From: Georgian Group Midlands & Northern Office <james.georgian@virgin.net>
Sent: 14 April 2016 18:54
To: planning
Cc: Consult
Subject: FAO: Mr Adrian Dowd -3/2016/0236 and 3/2016/0238 - Friends Meeting House, Sawley Road Grindleton, Lancashire - Georgian Group Consultation response

Thank you for informing the Georgian Group of a proposal to undertake alterations to the above GII listed eighteenth century former Friends Meeting House. The Group wishes to forward the following very brief comments on this scheme.

Existing Plans

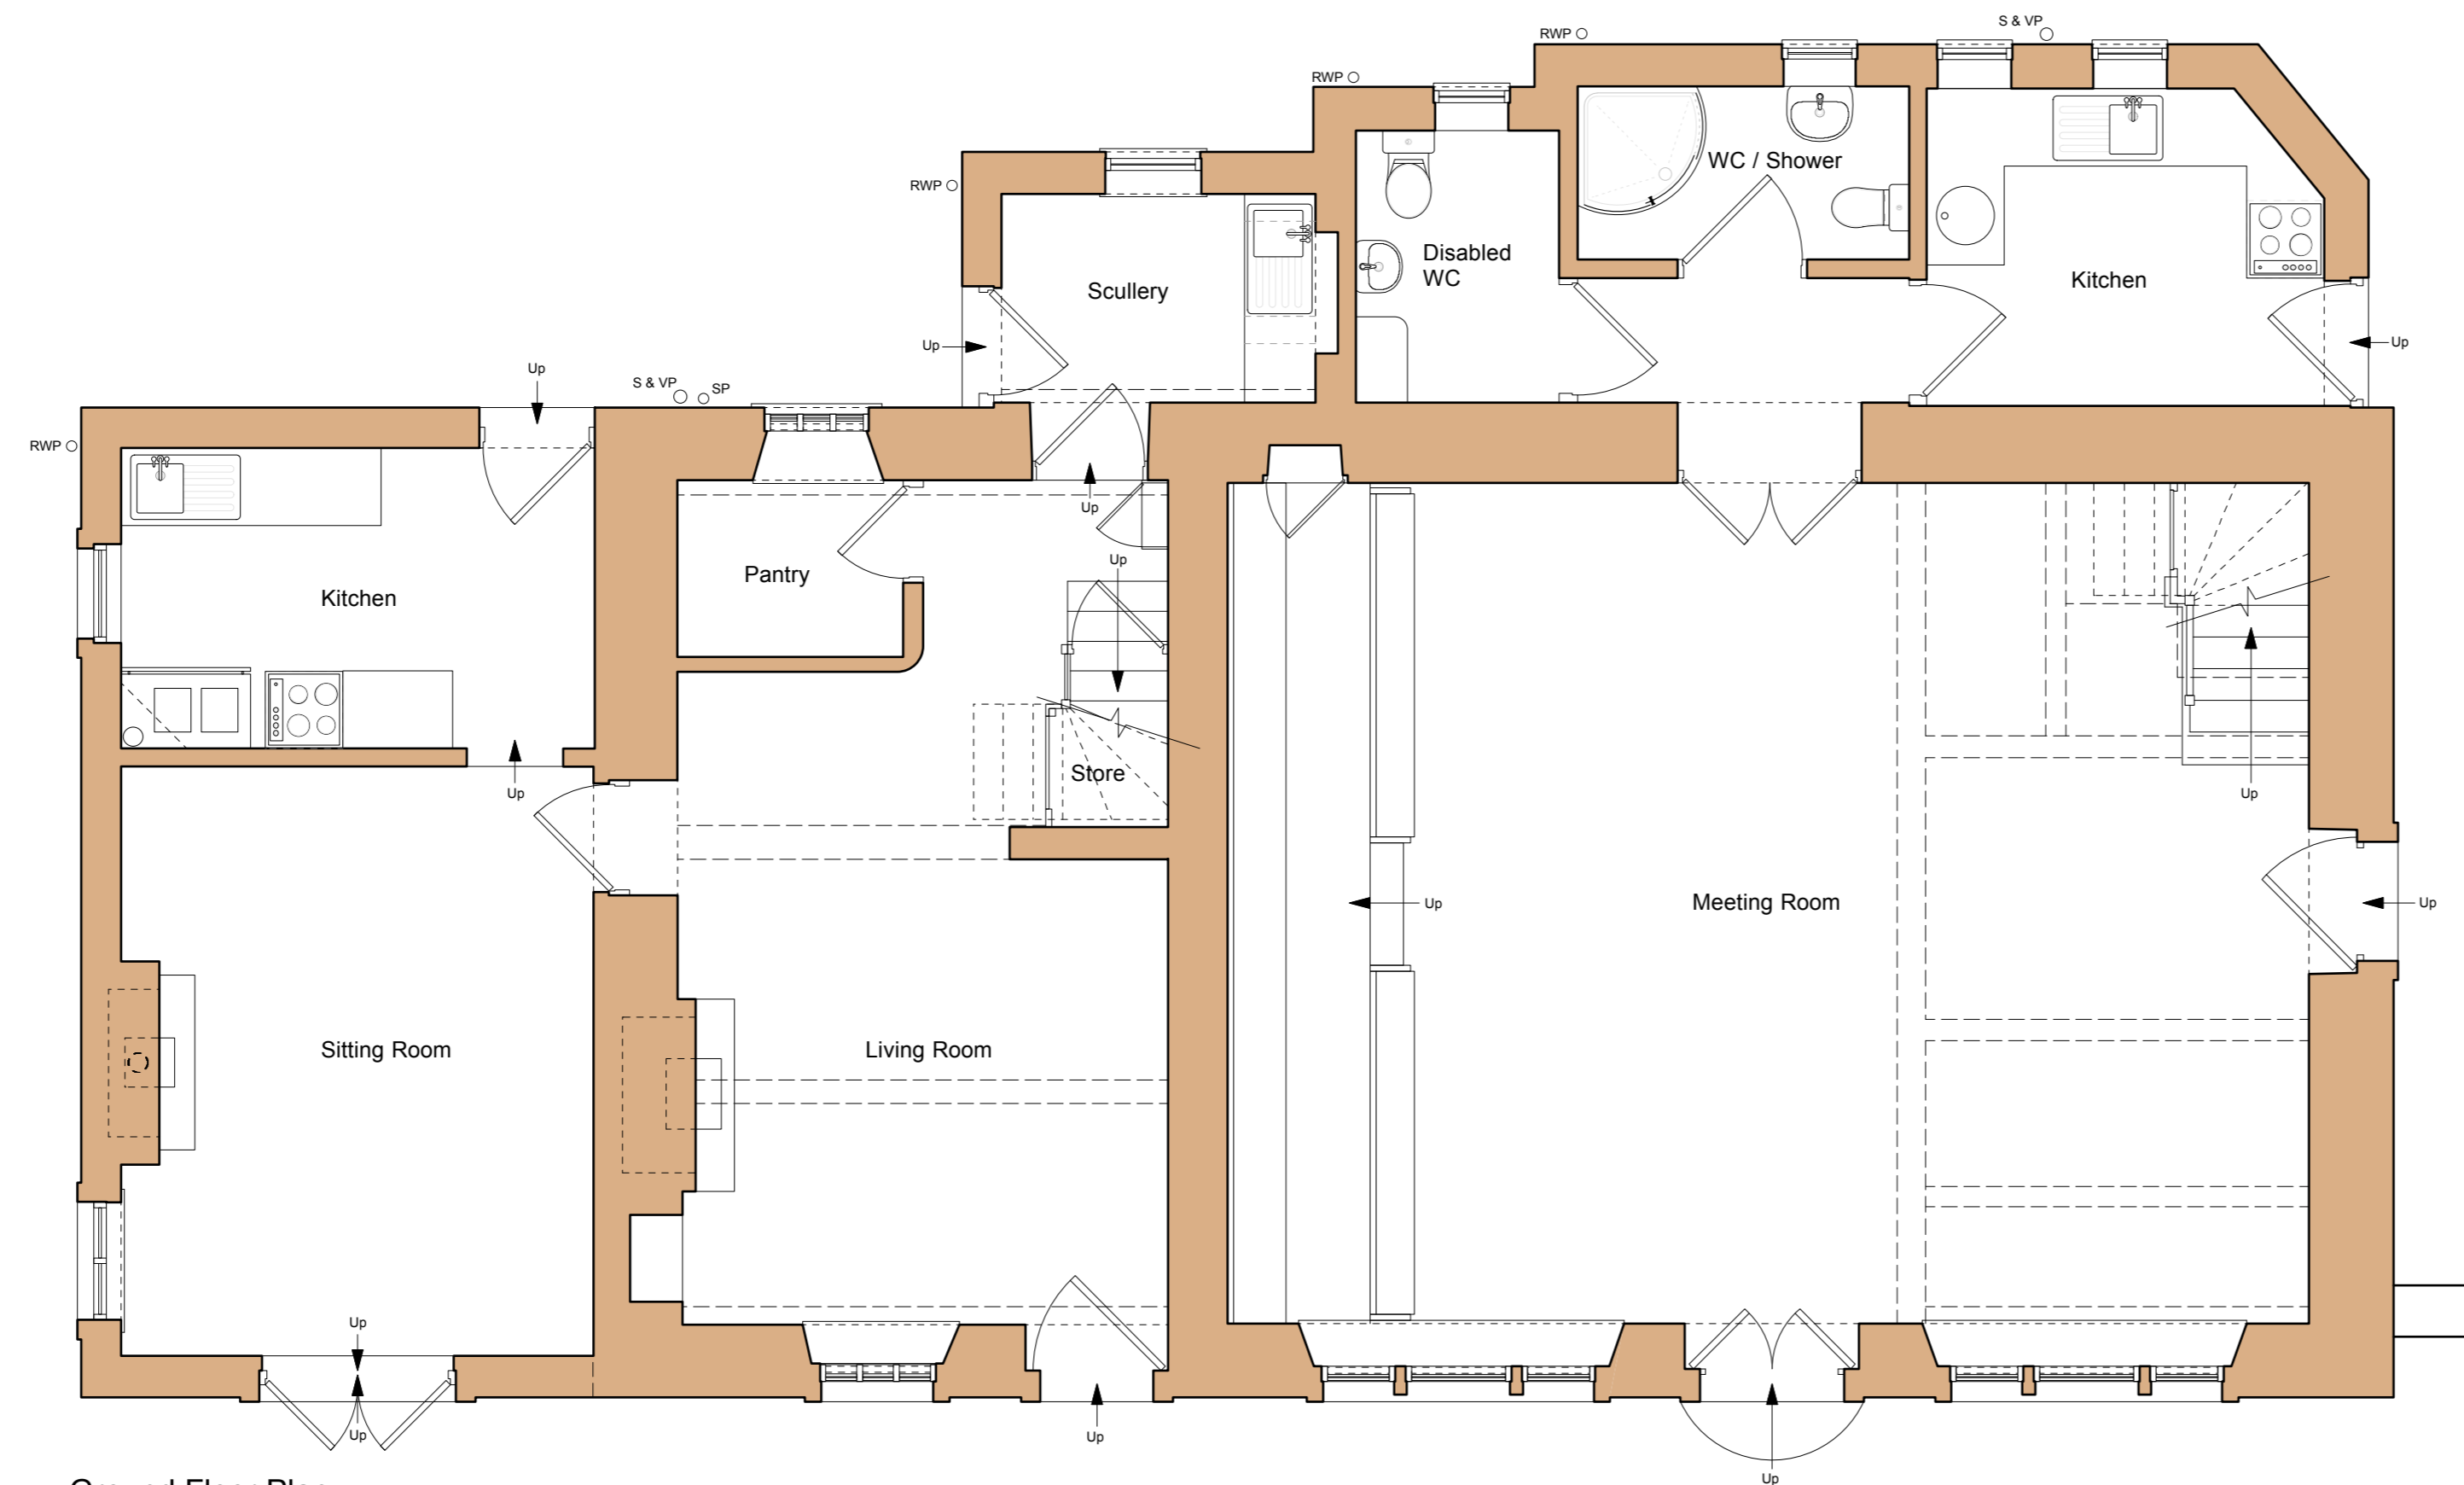
The building's most important internal spaces are the former meeting room itself and its enclosed gallery. The Heritage Statement somewhat underplays the significance of the surviving historic fixtures and fittings within the worship space which are relatively early and now rare survivals of their kind. It is not entirely clear from the supporting documentation that they are to be retained in situ, although it is inferred that this may be the case. Any proposal to remove them would need to be robustly justified.

We would urge your authority to ensure that there future is clarified prior to determining this application.
